Re: PNM Reeves Solar Array Project Engineering Certification
Engineer's Stamp dated 1-12-11, (D17/D102)

Re: PNM Reeves Station Solar Facility Grading and Drainage Plan
Engineer's Stamp Dated November 11, 2010, ZAP D-17

Re: PNM Reeves Station Solar Park Grading and Drainage Plan
Engineer's Stamp date 11-11-10 (D17/D102)

FLOOD ZONE, VICINITY, DRAINAGE BASINS

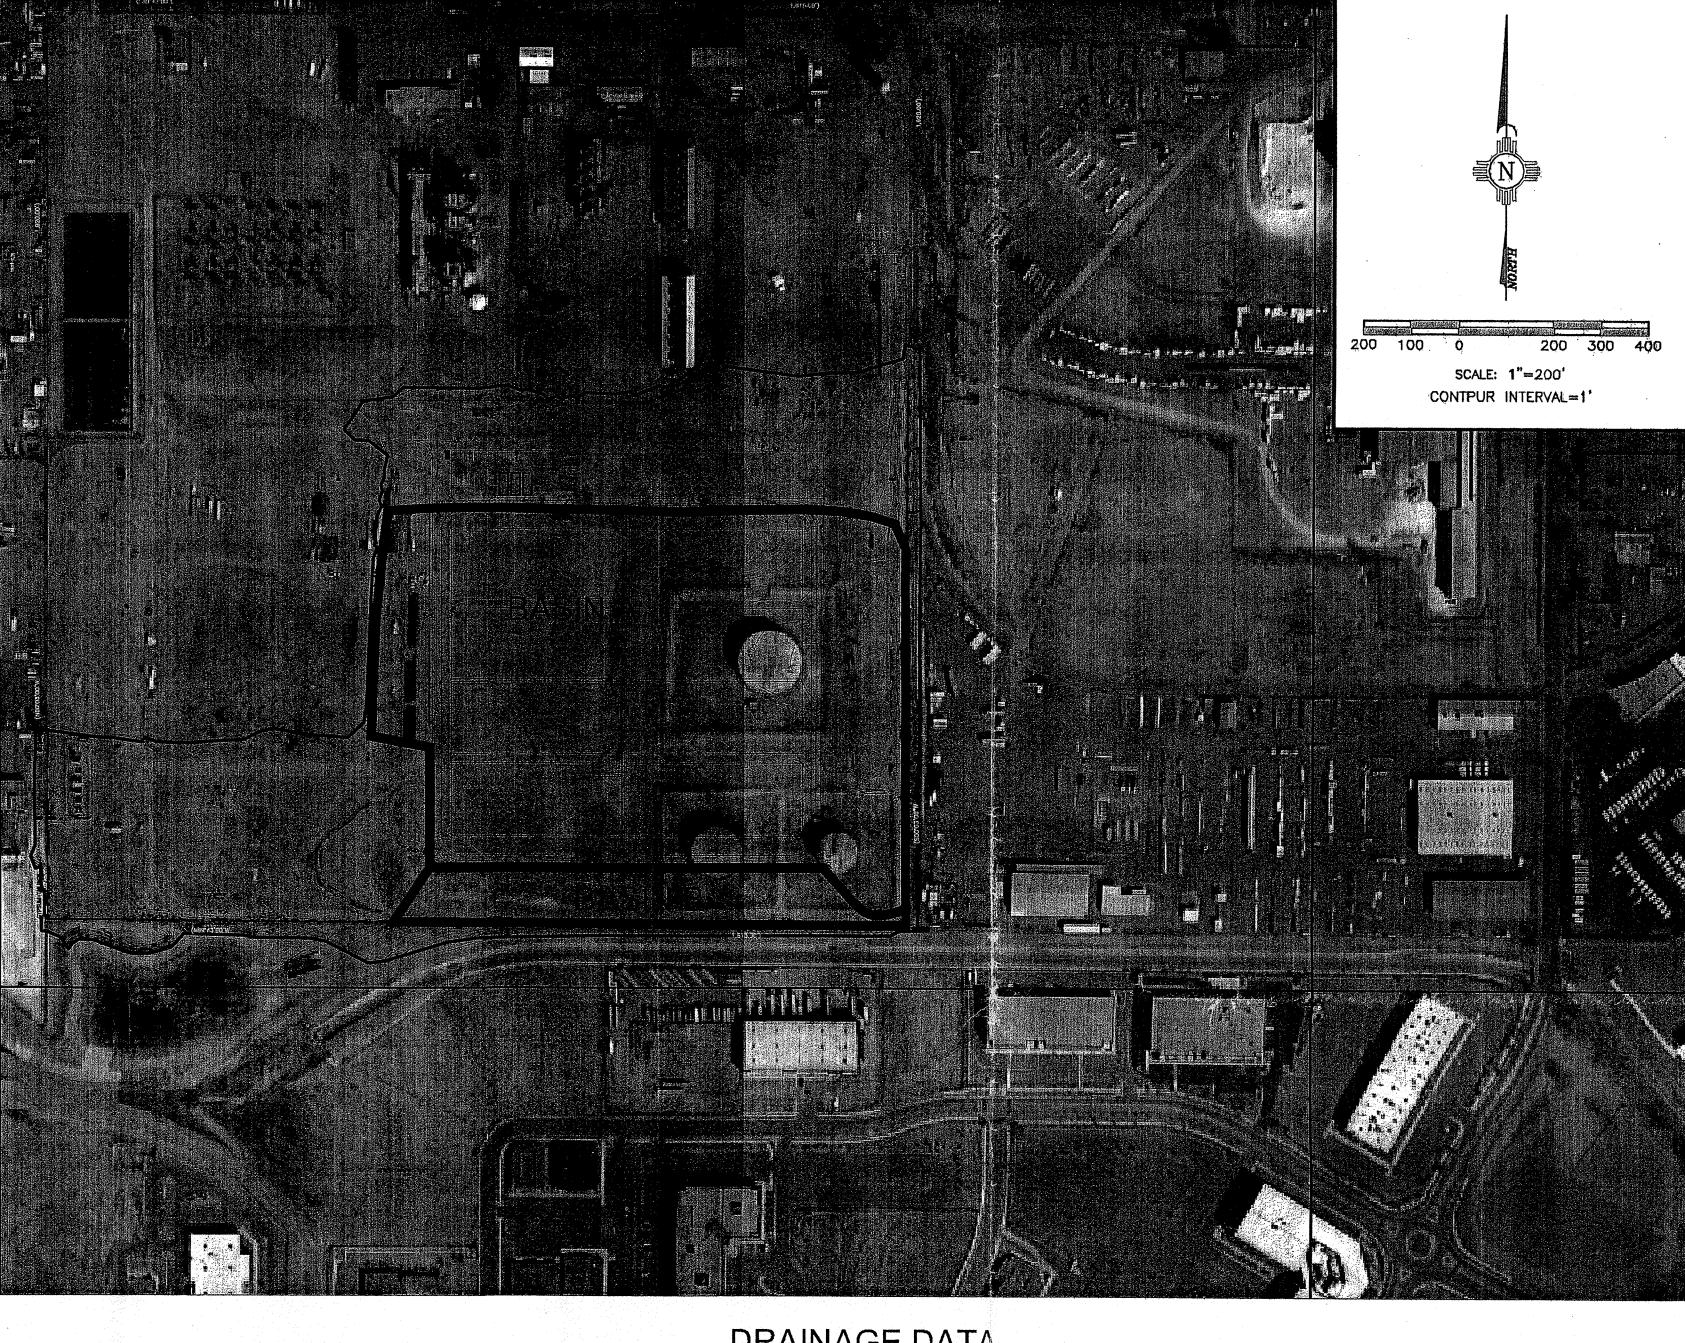
- Retention ponds must be sized for the 100yr-10 day storm. Please annotate the WSE, Volume Required and Volume Provided on Sheet USS-164902-2.
- Land Treatment "A" is used for land that has not been touched. It appears this area has been driven on and used for a storage yard. Once the site has been seeded, it would qualify for a Land Treatment "B".

- Why are the Existing and Proposed basins different sizes?
- The proposed new parking area should be included in a proposed basin. Will it be paved? The outfall for this area is unclear. This area should also be restricted to historic flows unless ponded.

GRADING AND DRAINAGE PLAN

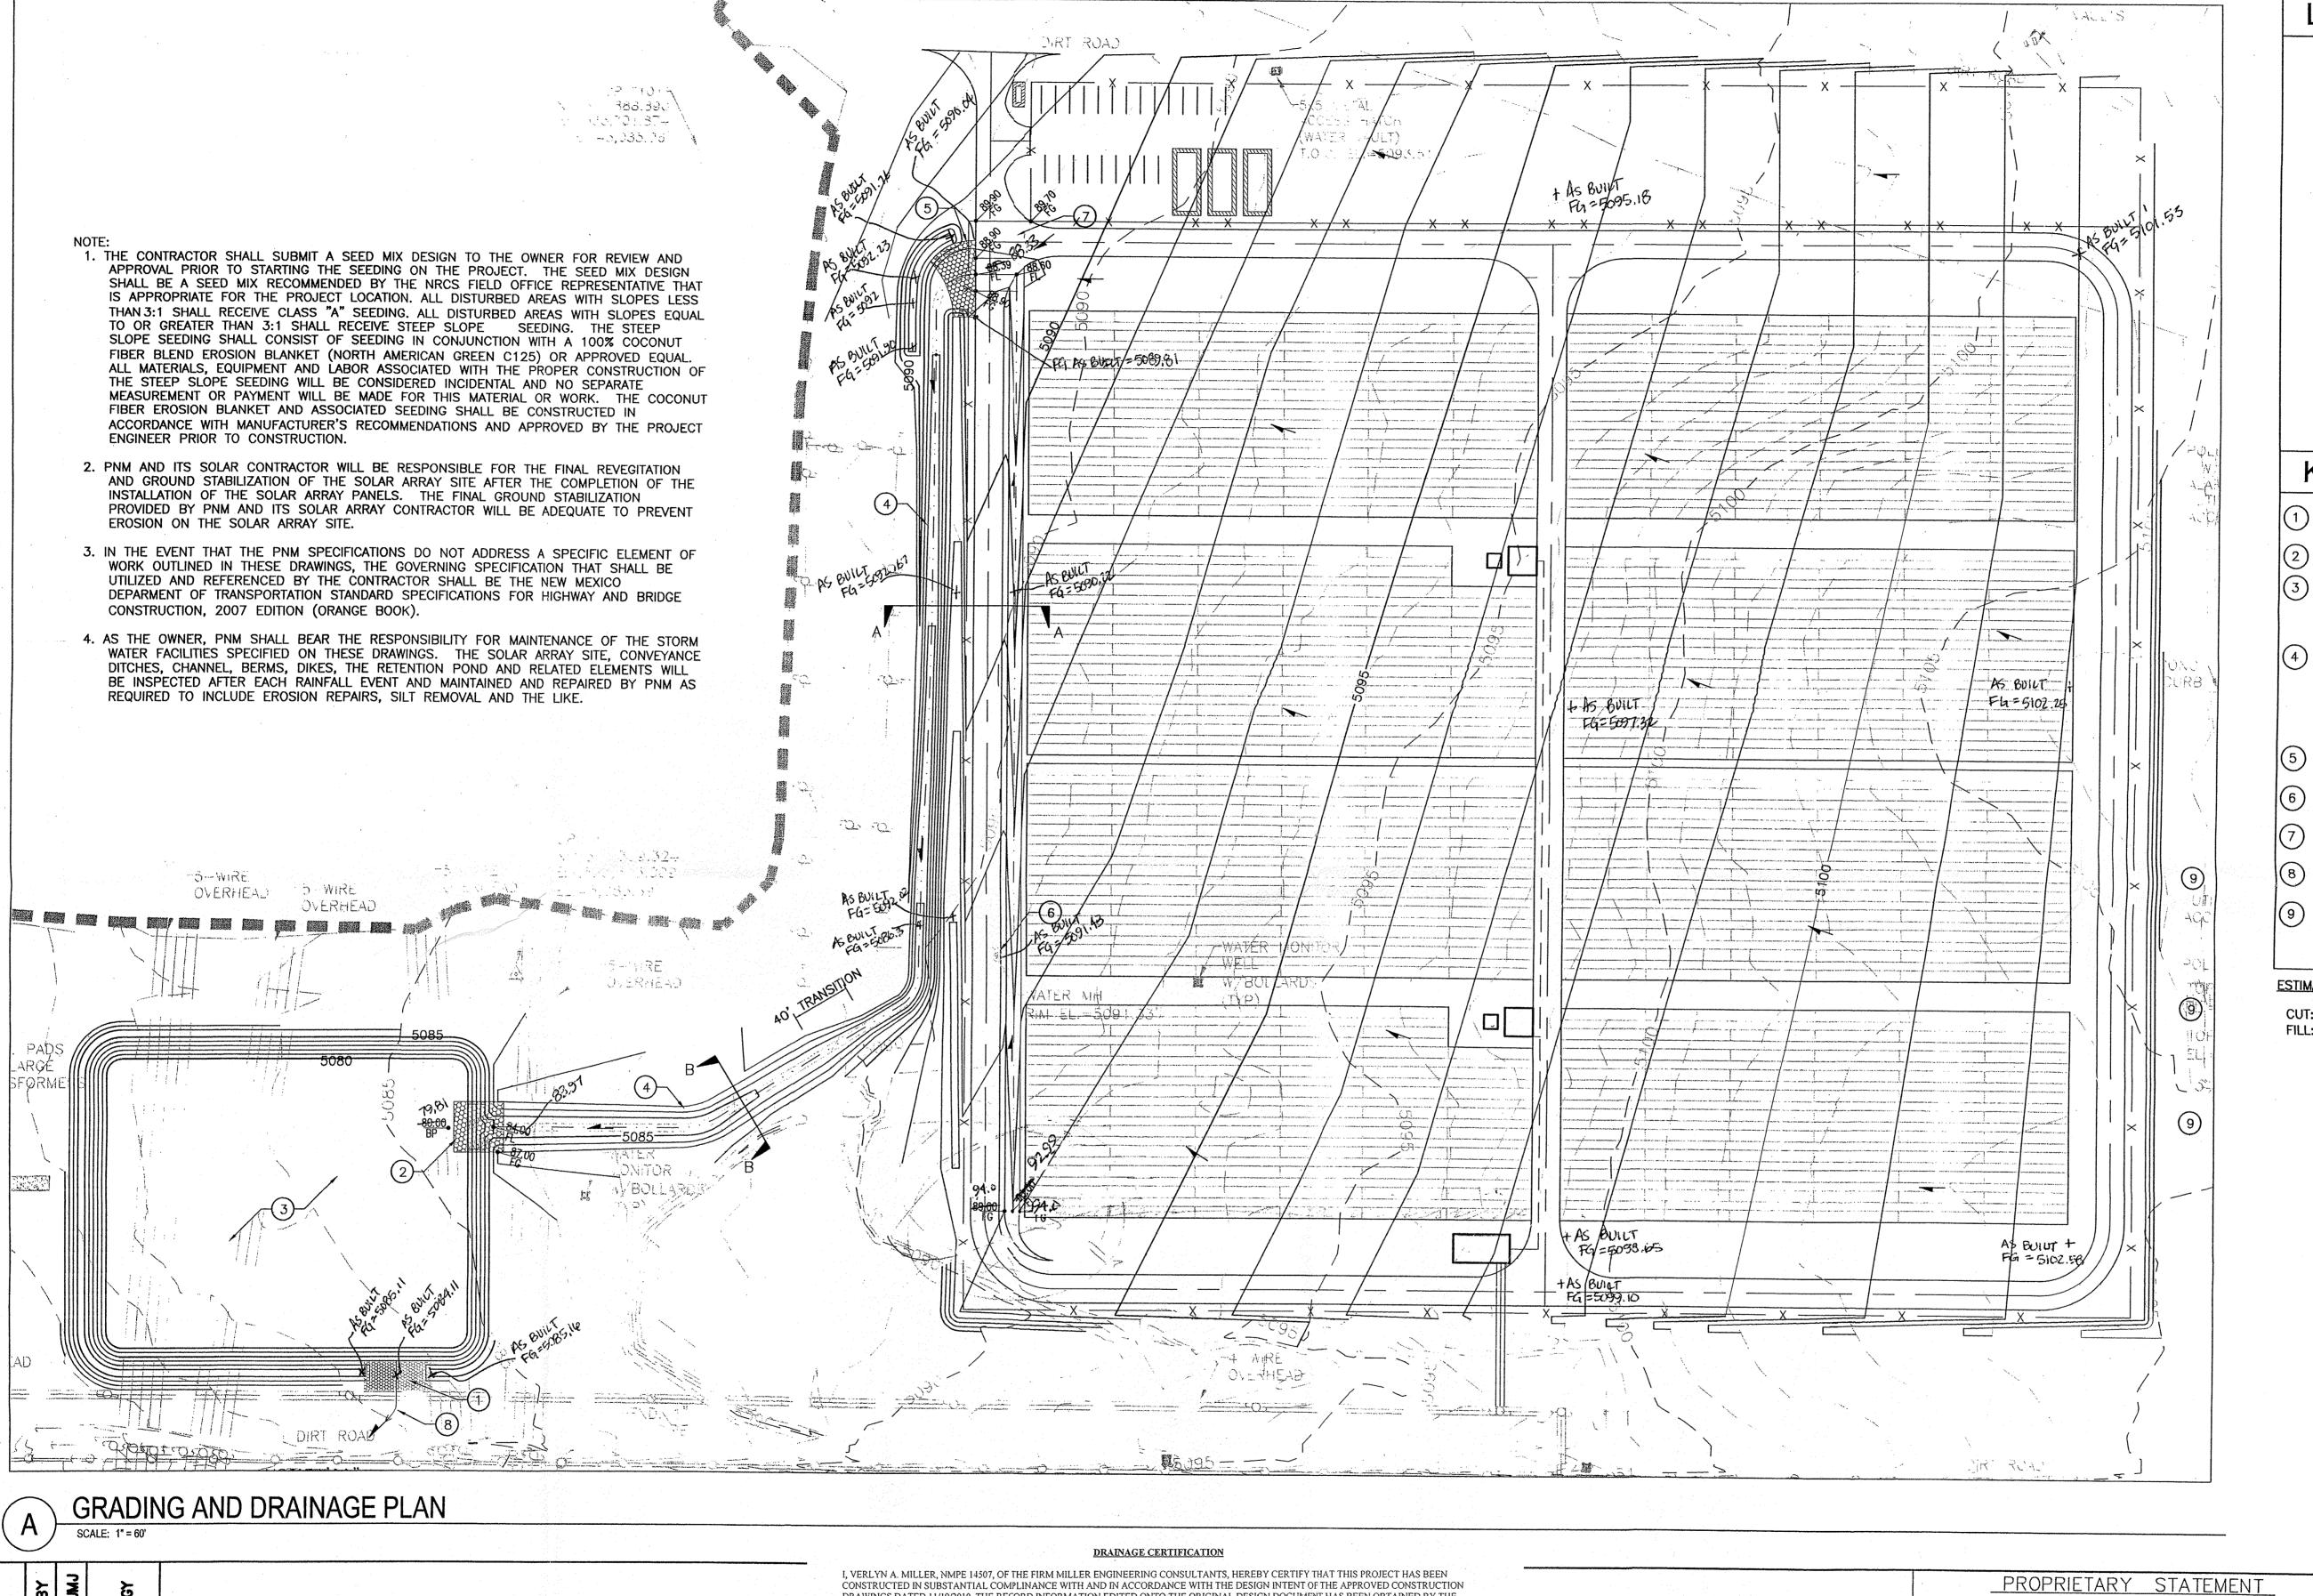
- The pond spillway should be moved since there is a building in the flow path in its proposed location. There are ponds south and west of this location, which would be a better direction for the pond to spill.

- Spot elevations at the southwest corner of the site are lower than the northwest corner. This contradicts the flow direction.
- At the northwest corner of the project, the plan proposes to turn approx 100 cfs 90 and 180 degrees. What is the velocity of the runoff at this point? How are you certain it will make this turn?

- At the same area discussed above, a cut will mostly develop as the flows cross the dirt road.
- Since this site is next to an AMAFCA facility, AMAFCA is being provided the plan for comment.
